Your Ref: OWPC26445
Our Ref: EP/37/20/HH 24-03-2020
Please ask for:
Zac Denton

Single storey side/rear extension, part two storey rear extension rear extension, raising of roof height to create a second floor and front double garage.

56 Angmering Lane East Preston Littlehampton

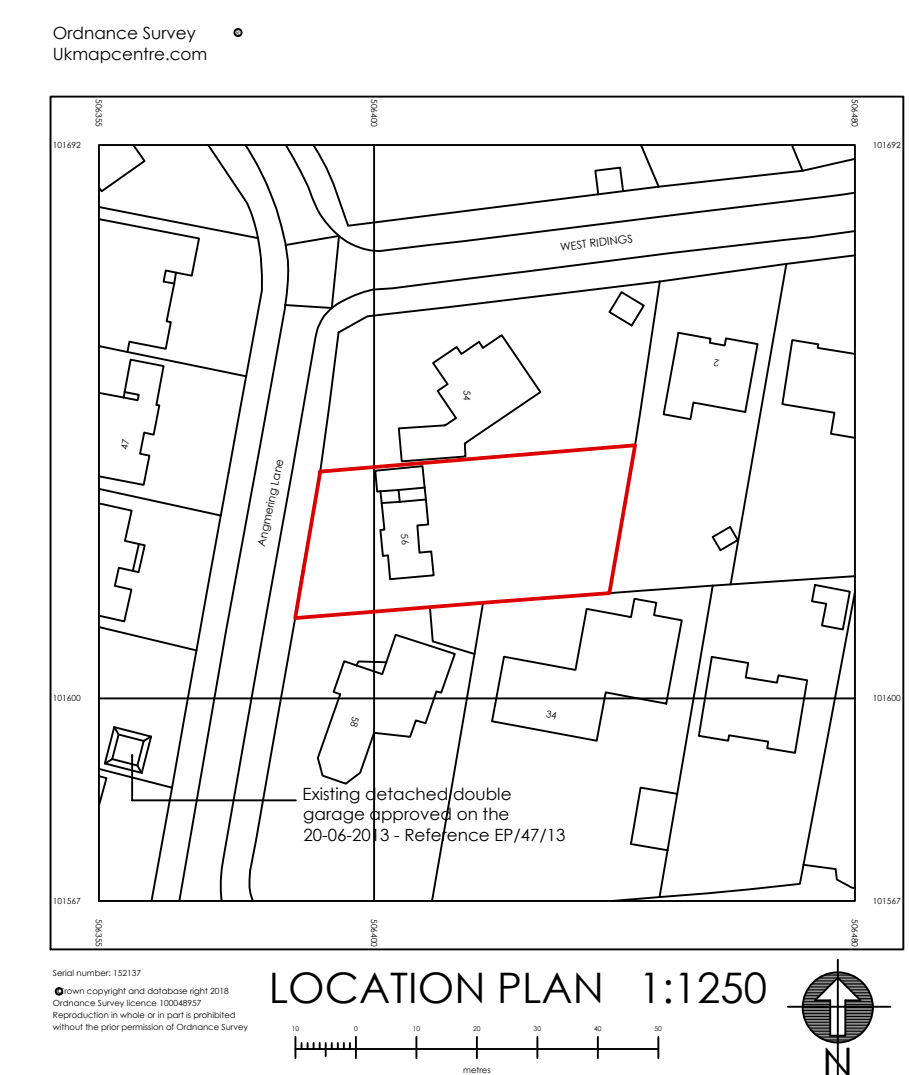
- a) It is a gross overdevelopment of the site, the extension being almost twice the floor area of the existing house - resulting in a house almost three times bigger, disproportionate to the size of the plot.*

- b) The addition of another floor and the raising of the height of the house with a flat roof is contrary to the neighbourhood plan, completely out of keeping with the surrounding properties and would give a brutal profile that dominates the area. All the other houses have a softer profile with pitched roofs. There are no properties on this estate with three floors and a flat roof.*

- c) The proposed location of the garage close to the front western boundary and road is entirely out of keeping with the rest of the estate and will change the "street scene", especially as it is in front of the building line. Further significant alteration to the street scene will include the cedar cladding on the walls of the garage and "zinc facing panels" for the second floor.*

We have significant concerns re the privacy of our property. The additional floor would give an overview of nearby properties, including most of our garden and would be a severe intrusion of our privacy. The intended provision of balconies, which would become viewing platforms, compounds such intrusion.
